**Consultation Response from KC,  
Trees**

**2024/92727 Land adjacent to, Ashbourne Drive, Liversedge**

**Erection of residential development 67 dwellings with associated access, parking, public open space, landscaping and infrastructure**

**Date Responded: 06/01/2025**

Revision	Description	
A	20/08/2024 Preliminary Issue	
Client	Newett Homes	
Project	Lower Blaccup	
Title	Tree Protection Plan	
Drawing No.	BA230585TPP	
Status	P	
Scale	1:500 @ A1	
Date	20/08/2024	
Drawn By	Checked	Approved
LB	MM	SB

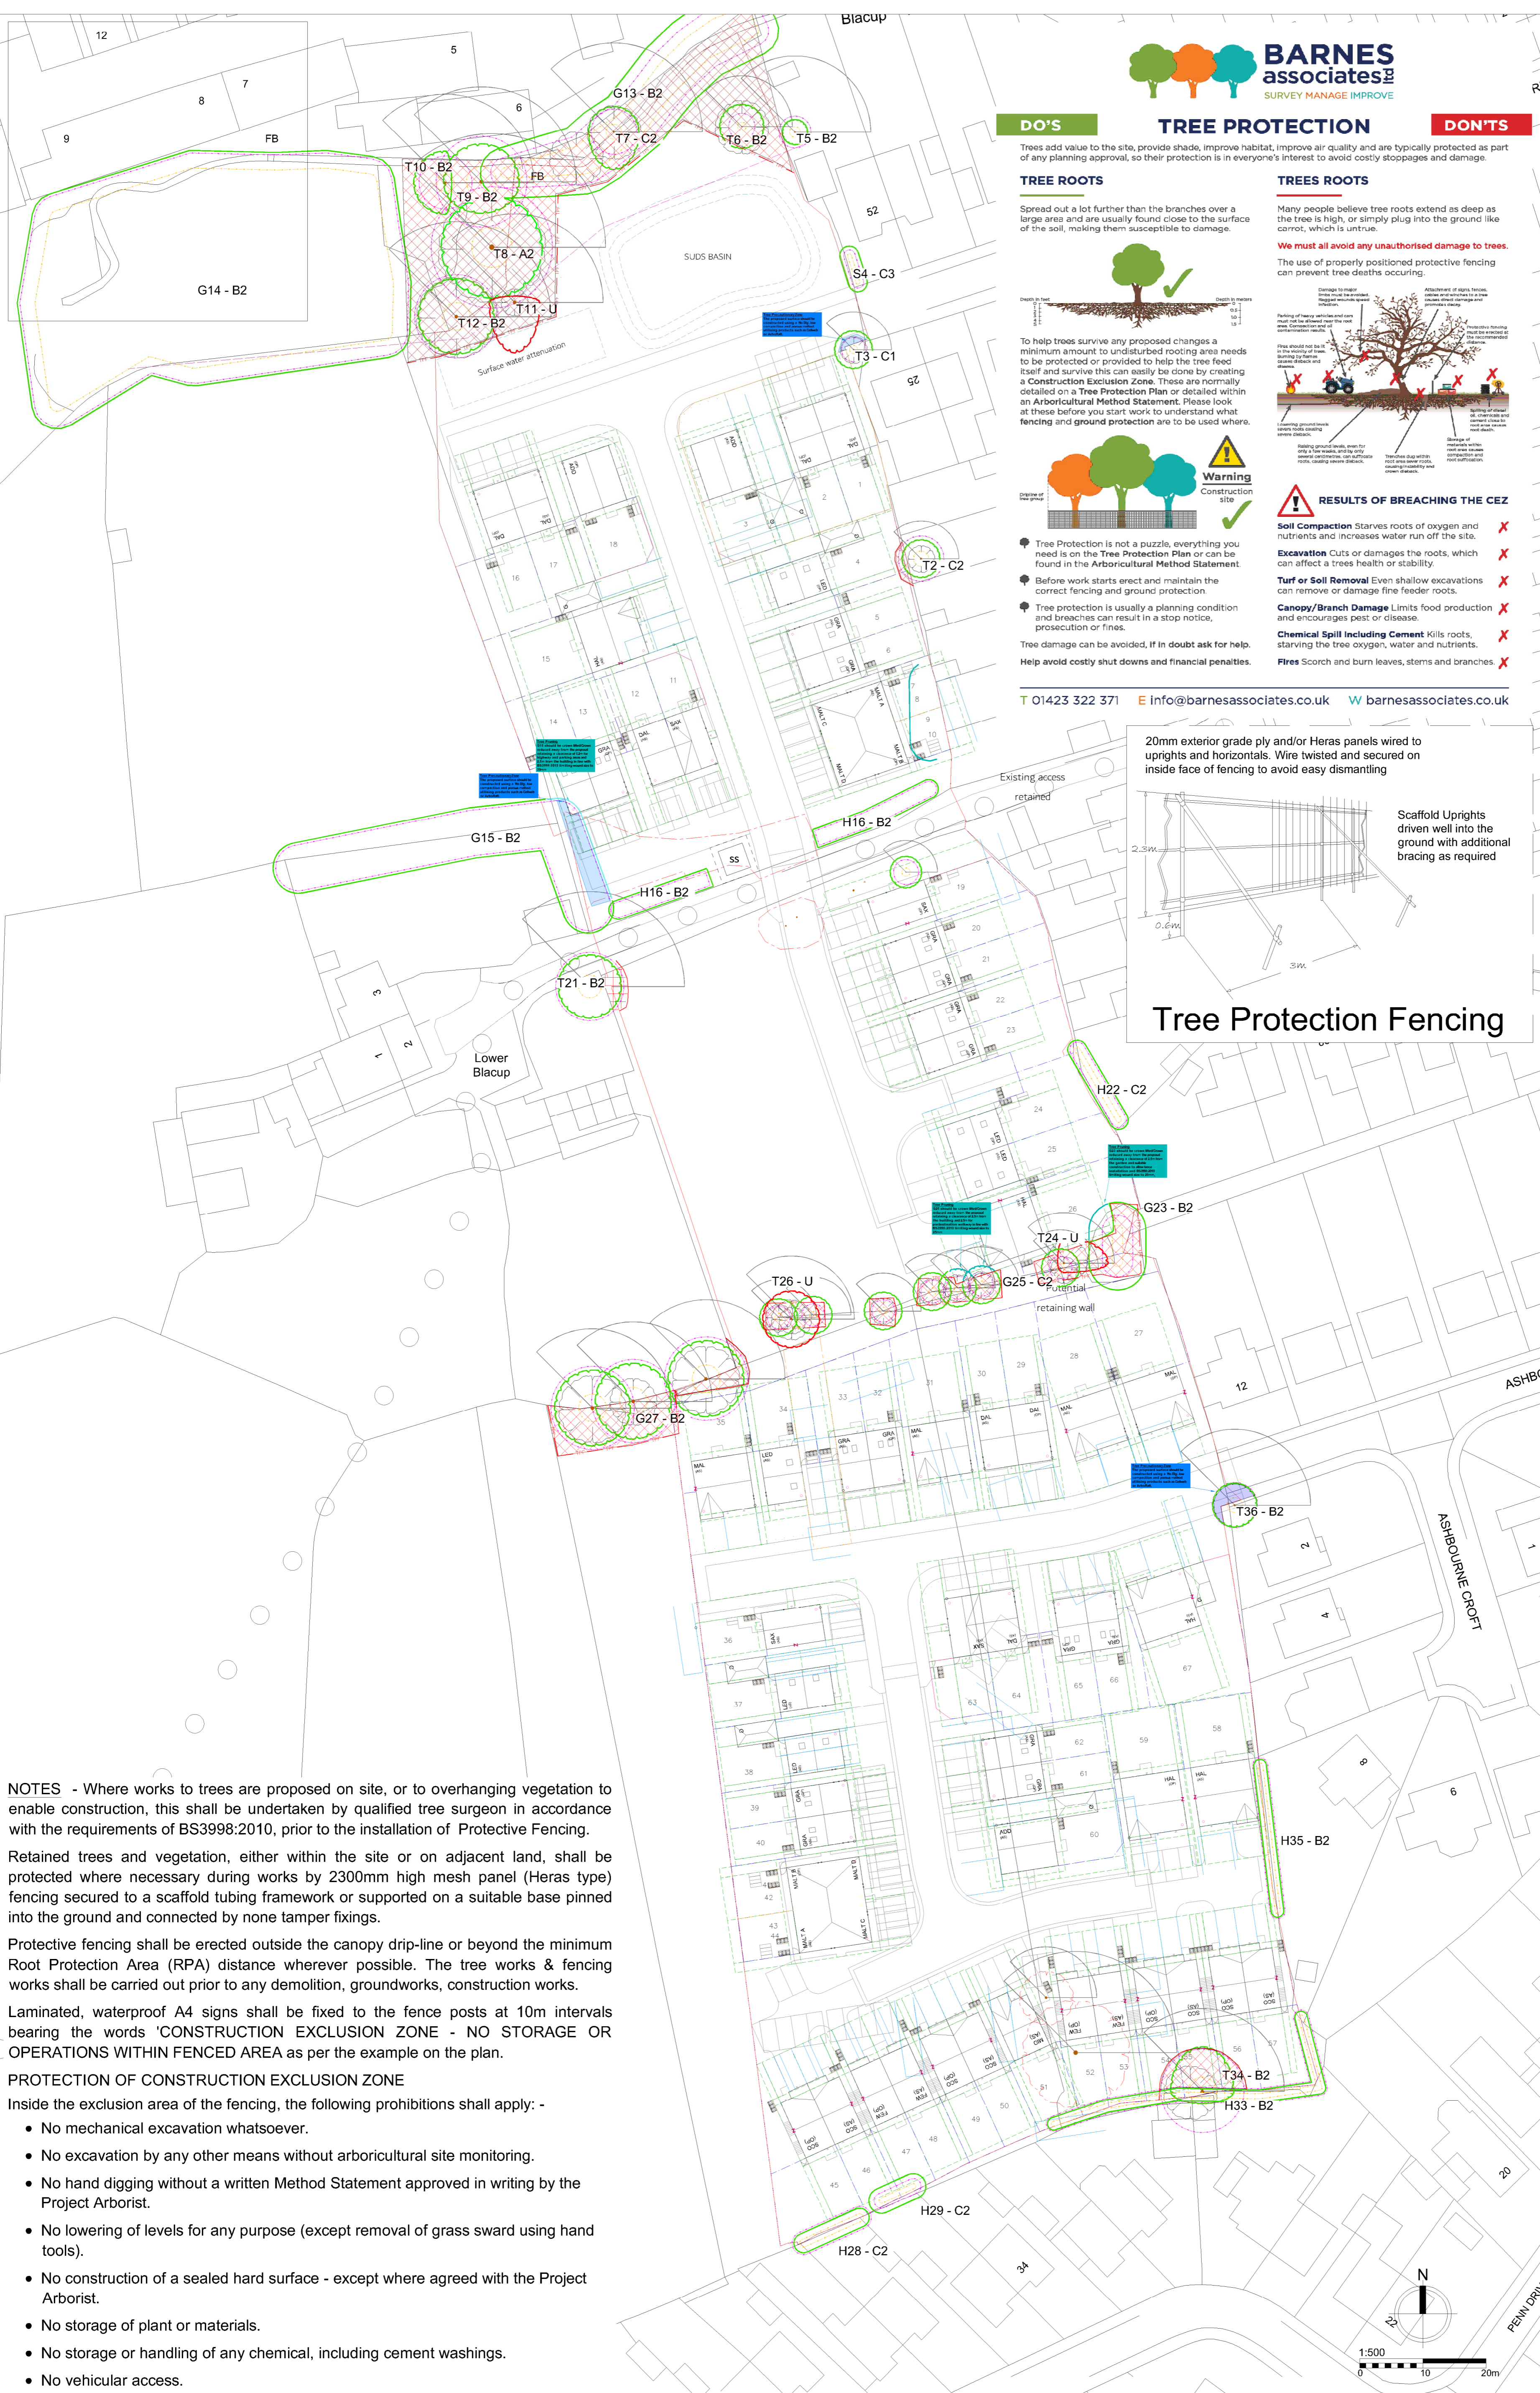
**The submitted tree survey information cannot be accepted, as all the tree positions and measurements are estimated. We require the tree information to be accurate to properly assess the impacts of the proposals on the tree constraints within the site. Additionally, the drainage layout and any ground level changes should be included as part of the amended arboricultural impact assessment.**

Plot 26 threatens retained Cat C trees from G23 (Cat B) and G25 (Cat C). Access facilitation pruning is suggested within the AIA. However, buildings and other structures should be sited allowing adequate space for the natural development of trees, with due consideration given to predicted height and canopy spread. Plot 19 threatens T19 (Cat B), which appears on the AIA as retained but within the report is suggested for removal along with T17, T18 and G20.

Title: Tree Survey & Constraints Plan

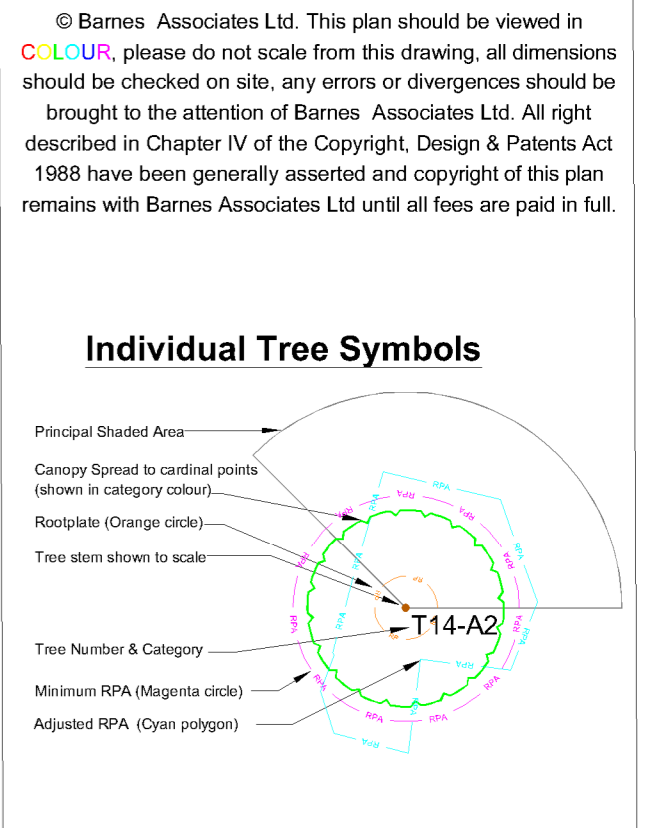
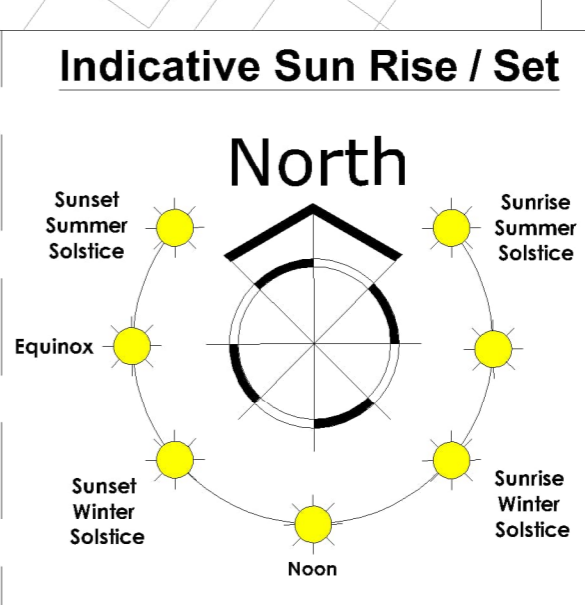
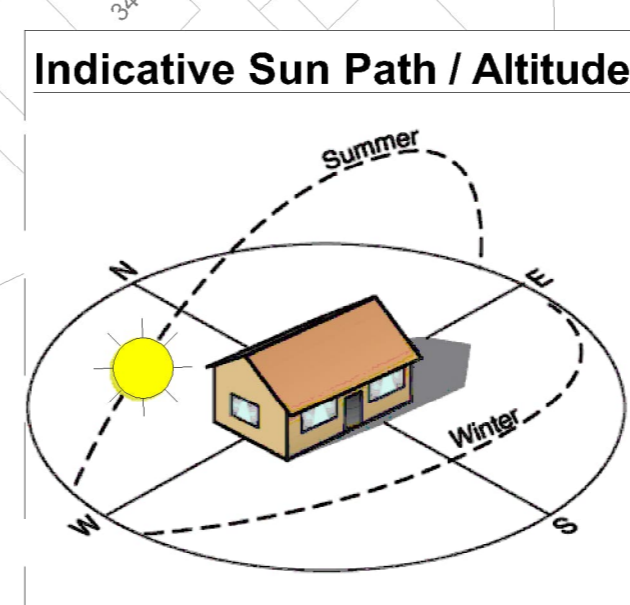
The submitted reporting suggest that the development of the proposals would require the removal of 2 Cat B trees (T30 and T31), 2 Cat C trees (T17, T18), 2 Cat B groups (G1 and G20), plus one complete hedge (H32) and one partial hedge (H16).

To align with Local Plan Policies LP33 and LP24(i) plots 51, 52 and 53 should be dropped to allow for the retention of T30 and T31. These are Cat B trees which offer good amenity value to the surrounding area and contribute to the environment.

RPA incursions also affect T3, T12, G15, G27.

**There is a holding objection from an arboricultural perspective. The reporting must be completed with accurate tree information, including tree positions, DBH, RPAs and crown spreads. Furthermore, the proposal includes the removal of Category B trees and conflicts with adopted Kirklees local plan policy 33 and 24 (i):**
